14 January 2021

EN010092 – Thurrock Flexible Generation Plant – Non-Material Change Request

This document is not to be used in whole or in part other than for the intended purpose and project for which it was prepared and provided.

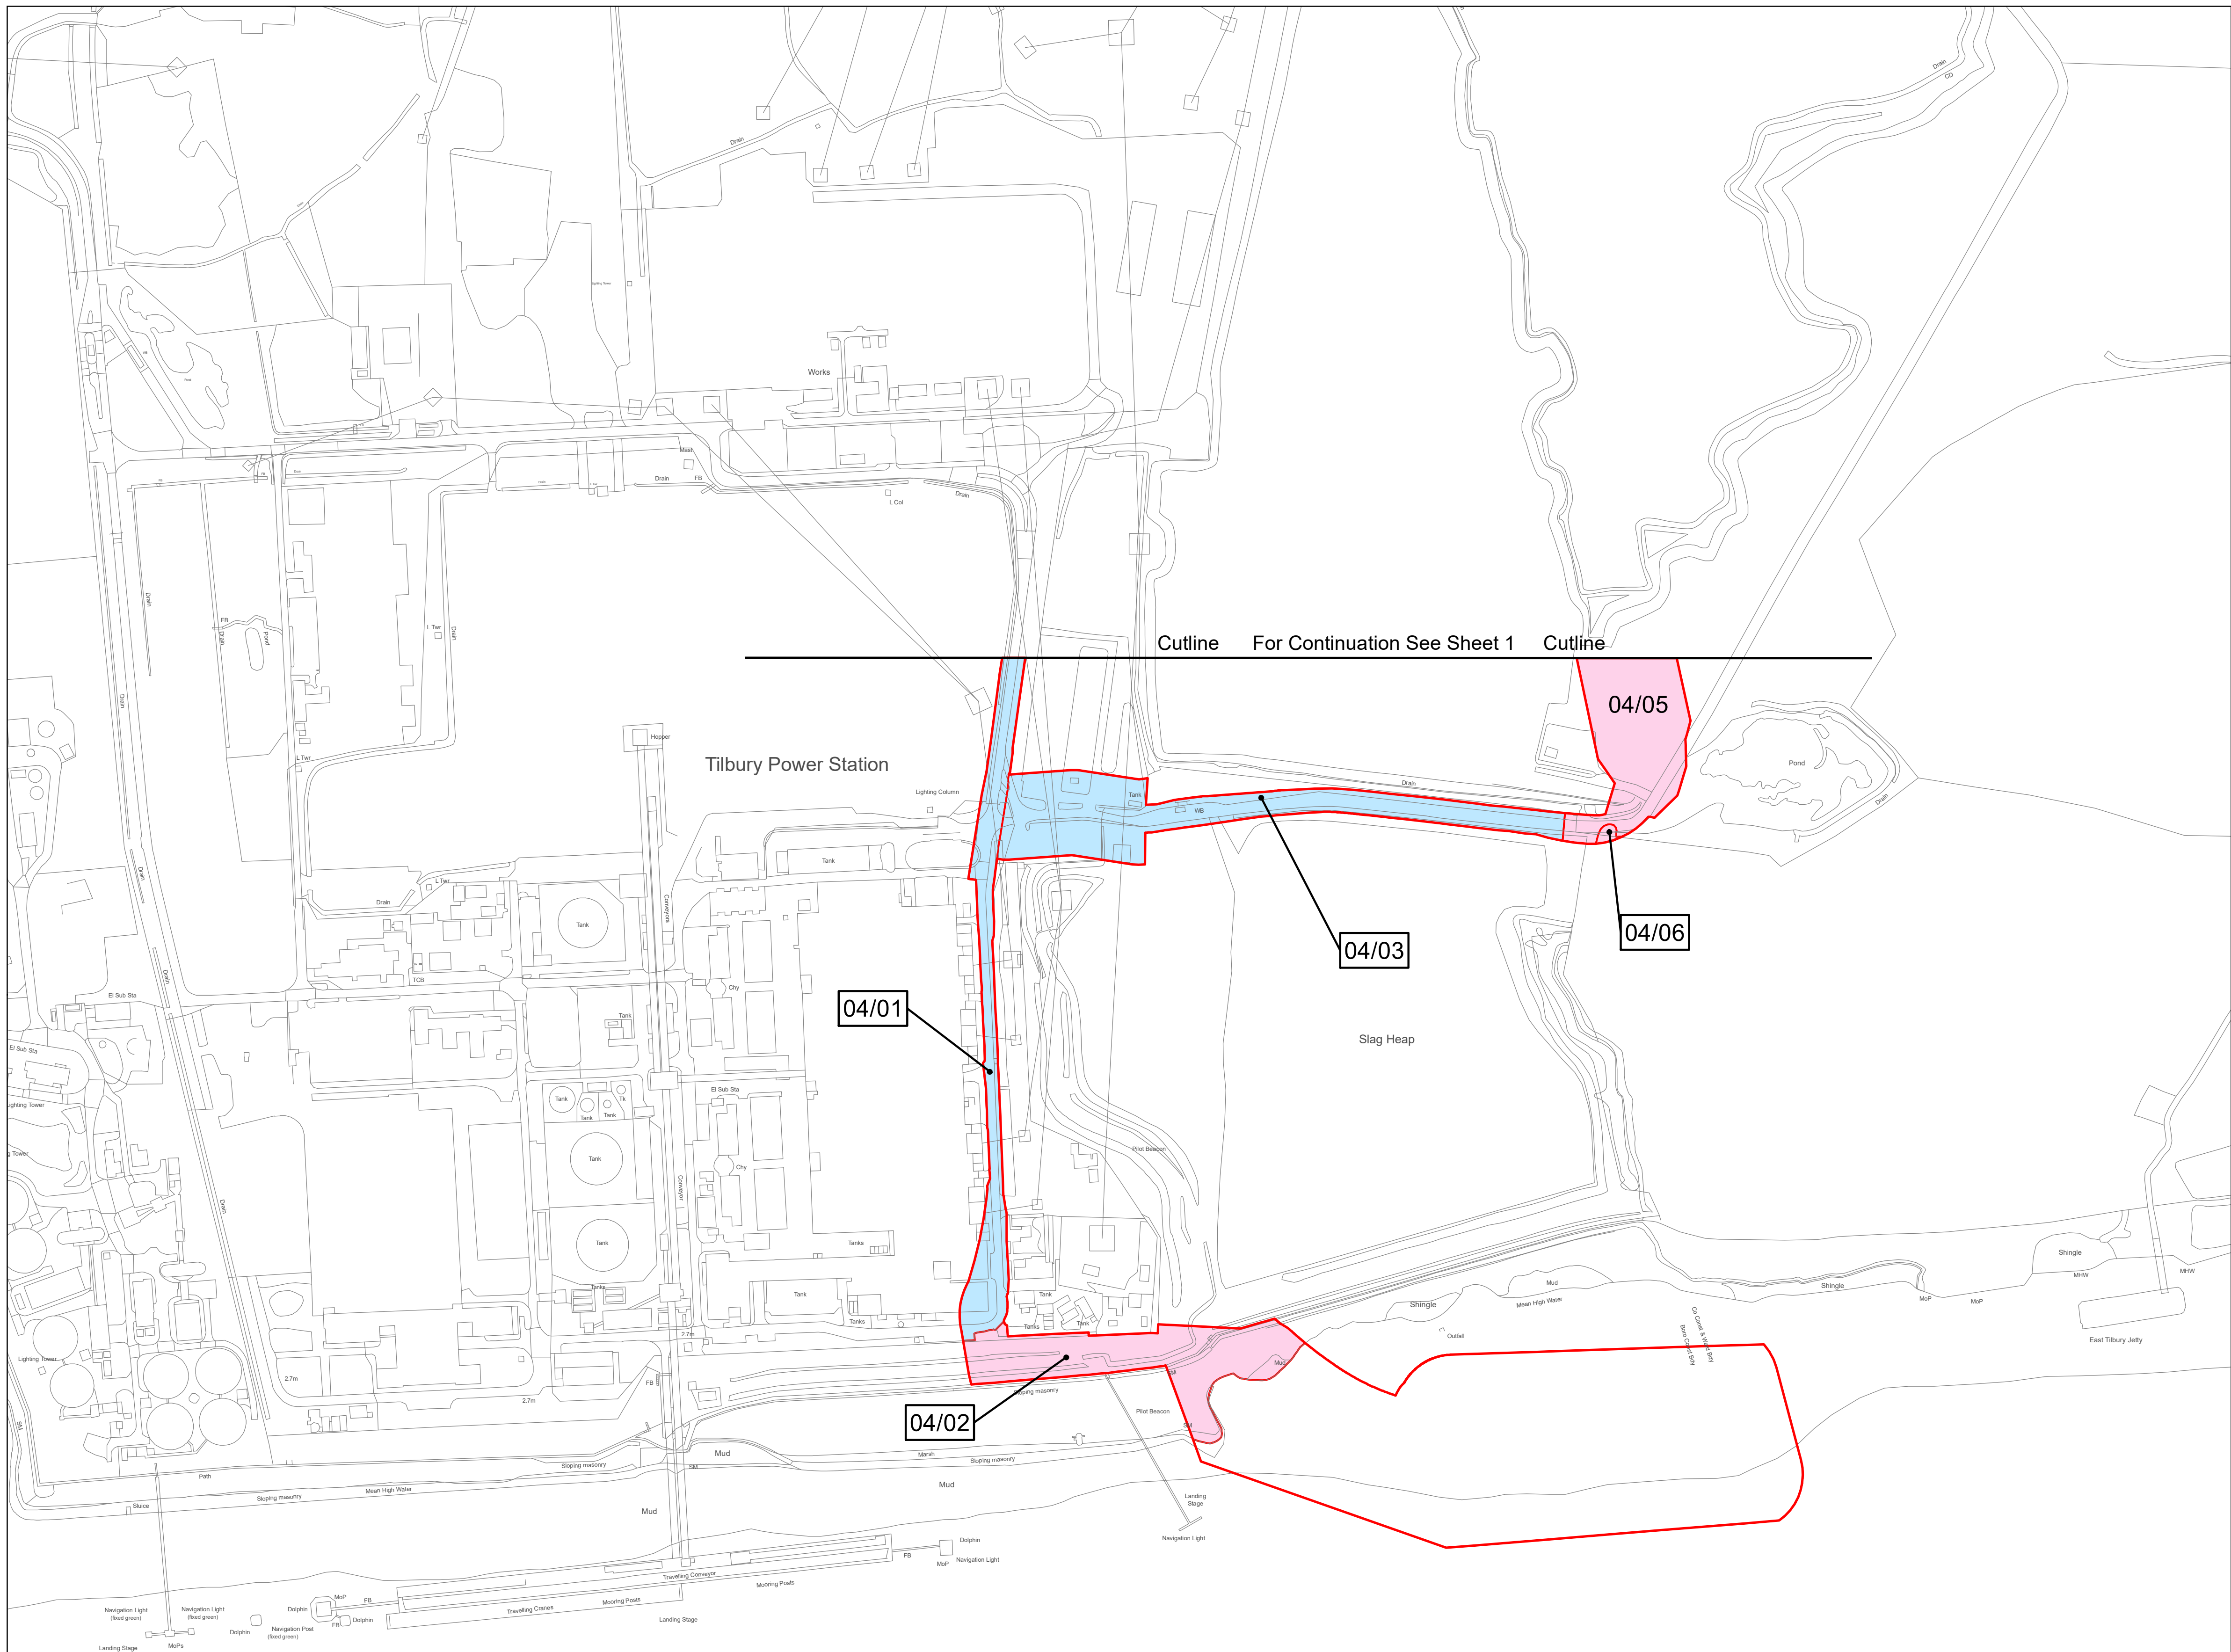
The Applicant has noted the objection made by RWE about the proposed acquisition and use of a plot of scrubland adjacent to the north-eastern corner of Tilbury Substation for habitat enhancement. This land forms part of Work 2 and was described as 'Zone F4' of the habitat creation and enhancement proposals in the Environmental Statement (ES). It comprises around half of plot 01/20 in the Land Plans.

Following further discussion with RWE and a review of other available land within the Order Limits, the Applicant has decided to remove the Zone F4 land from the Order Limits. Habitat creation is instead now proposed in the area of agricultural land between the main development site and the railway line (part of what is described as 'Zone C' in the ES), within plots 01/17 and 02/06.

The change does not add any new land to the Order Limits and reduces the land affected by the powers sought. The removal of 2.2 ha from Plot 1/20 has been proposed in direct response to a request from the affected landowner. The amendments made to the Book of Reference in relation to this change do not add any new interests.

This does not affect land acquisition as the entirety of plots 01/17 and 02/06 were already proposed for permanent freehold acquisition. The remainder of plot 01/20 remains in the Order Limits as it is required for the construction of an access route to the main development site.

The replacement habitat creation within Zone C provides an equivalent quantum of habitat and an increase in biodiversity net gain value compared to the previous proposals for Zone F4. The label 'Zone F4' is retained and applied to the new location of replacement habitat creation in updated ES documents, as discussed below.
